Consultation Response from: KC Environmental Health (Pollution & Noise Control)

2022/93397 Highfields Centre, New North Road, Huddersfield, HD1 5LS

**Responding Date:
14th February 2023**

**Drawing Title:** Proposed Ground Floor Plan: Building A and toilet block and all floors: Link and Tower Buildings

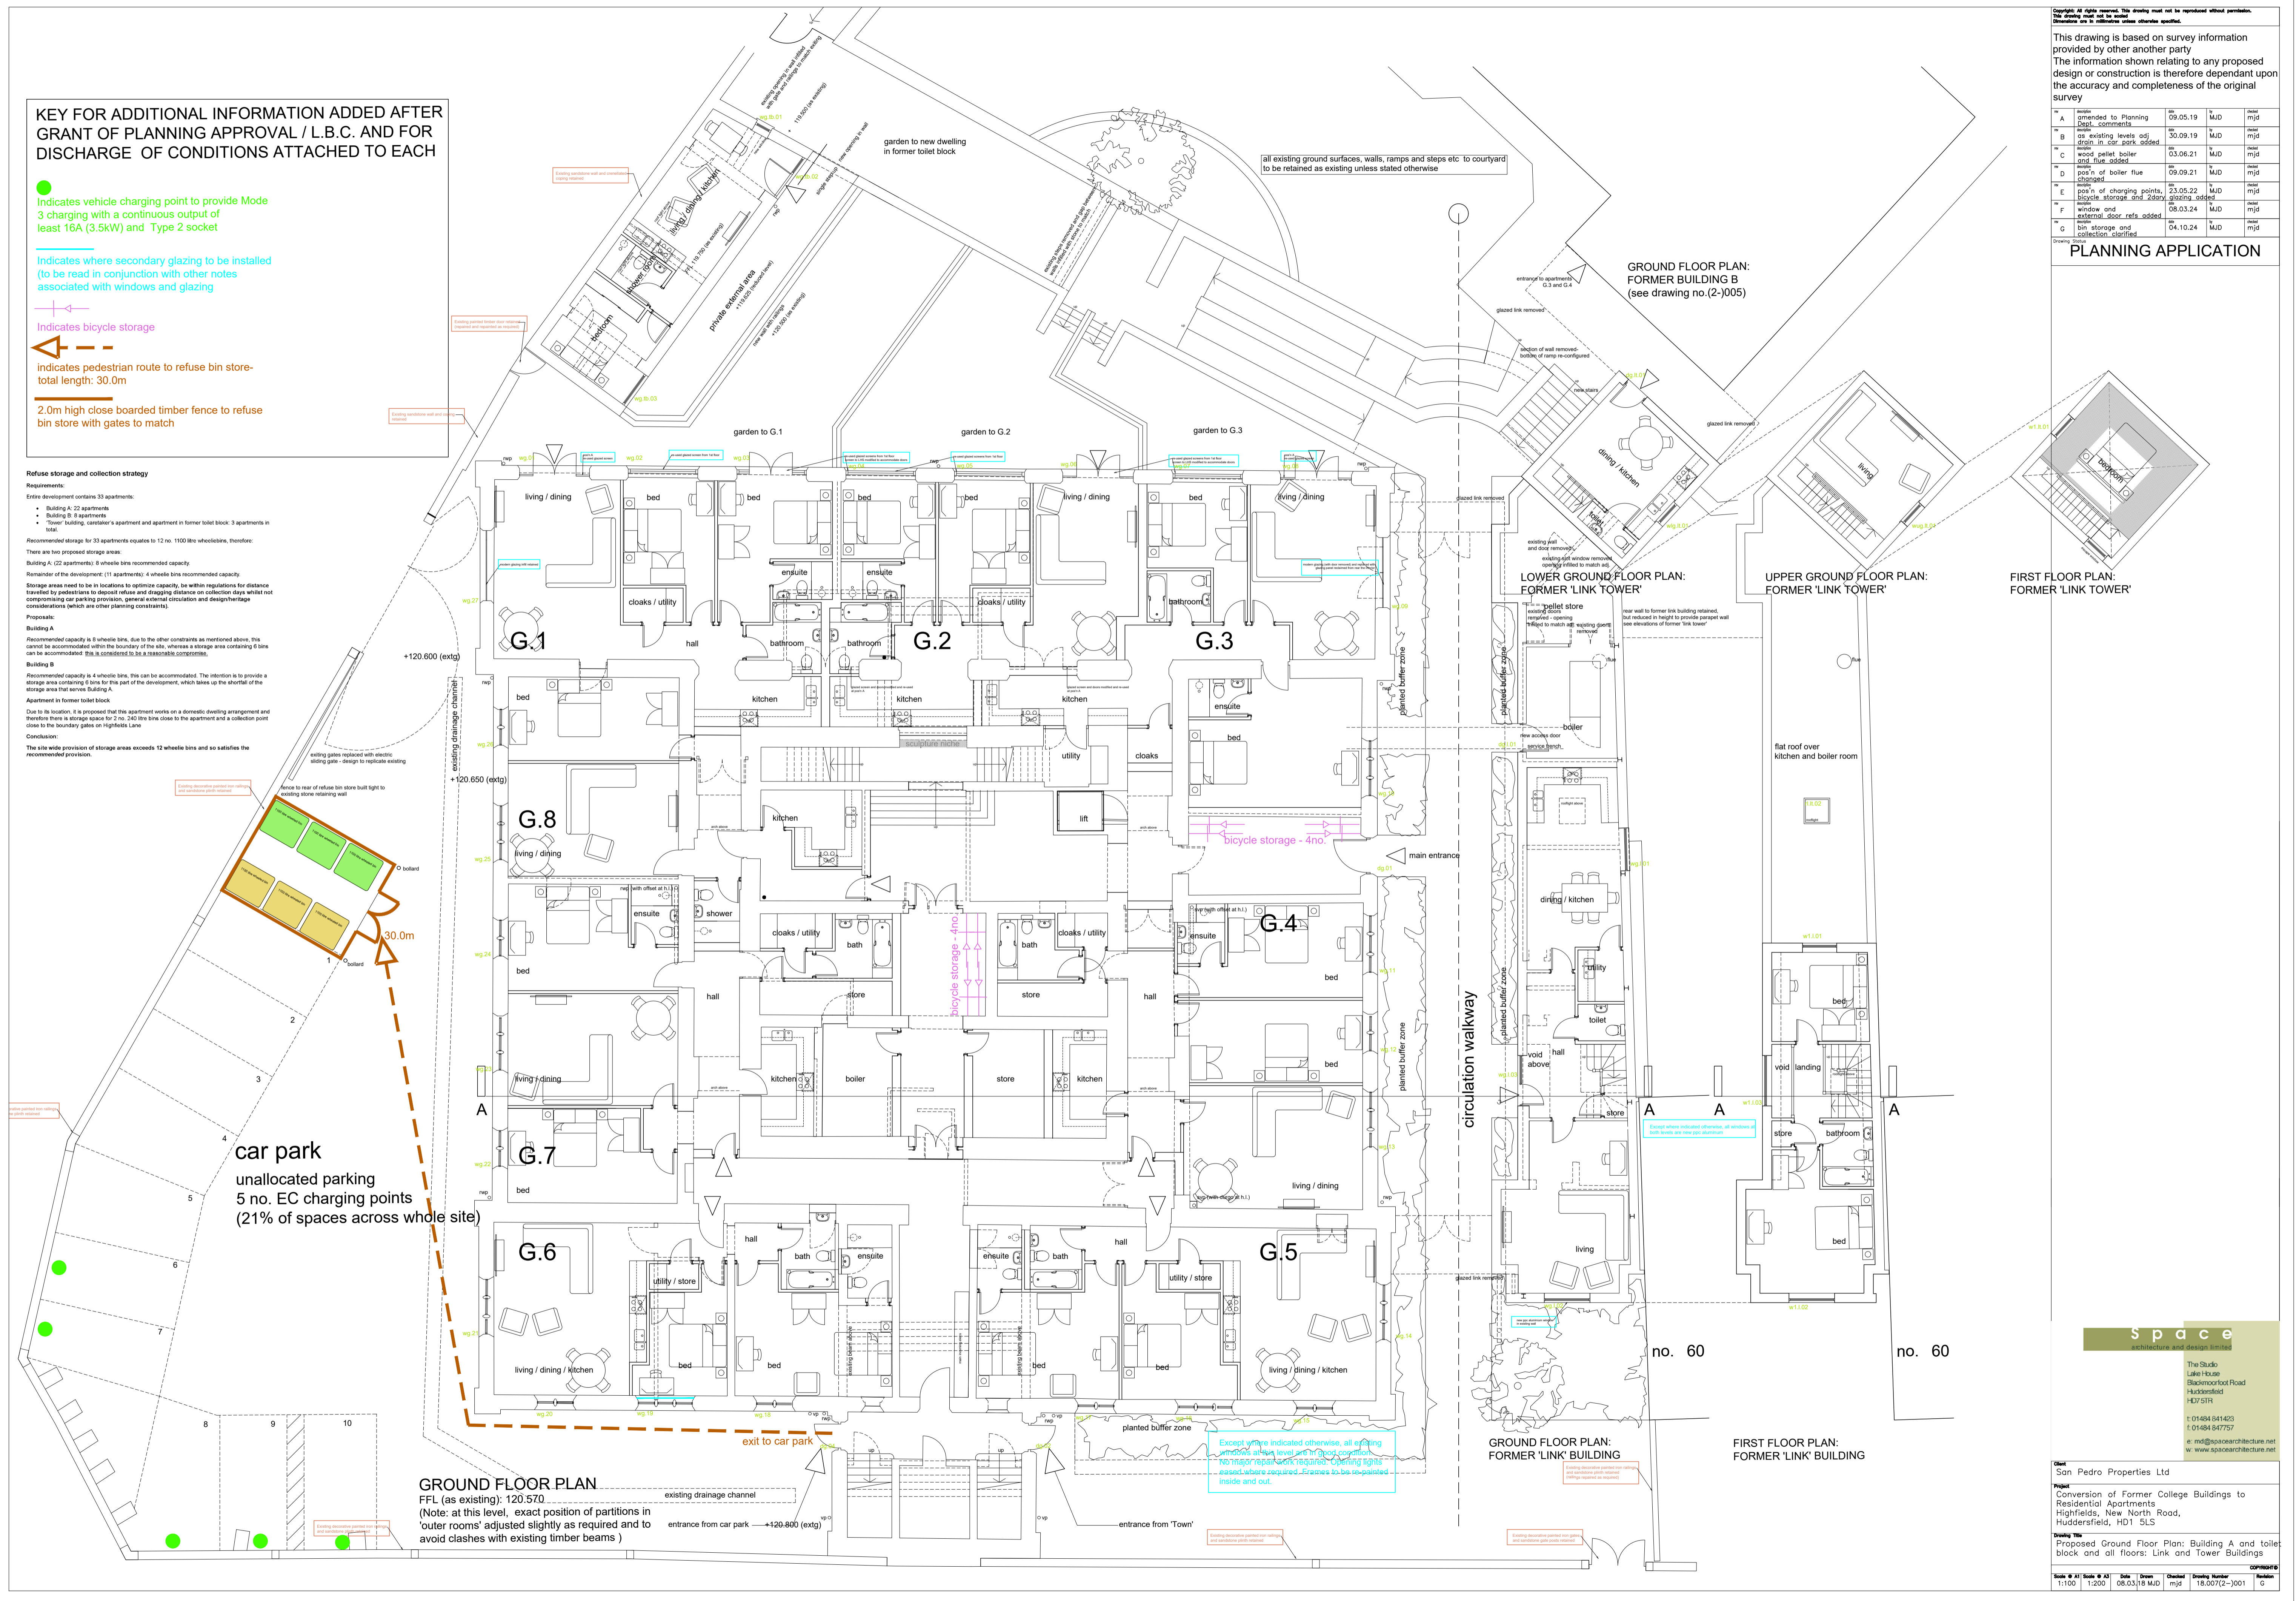
In support of the discharge of condition 5 a plan by Space Architecture and Design Limited, titled Proposed ground Floor Plan, drawing number 18.007(2-)001, revision E, dated 08/03/18 shows 10 parking spaces with 5 EVCP'S detailed, annotation clarifies Mode 3 charging with a continuous output of 16A/3.5Kw. Whilst we accept this information we understand there is additional parking associated with the development which is not shown. The applicant is required to provided details of all the parking and clarify if this is allocated or unallocated parking. therefore the information is insufficient to discharge the condition.

Due to the reasons listed above the submitted information is insufficient therefore we recommend that condition 3 is not discharged at this time.
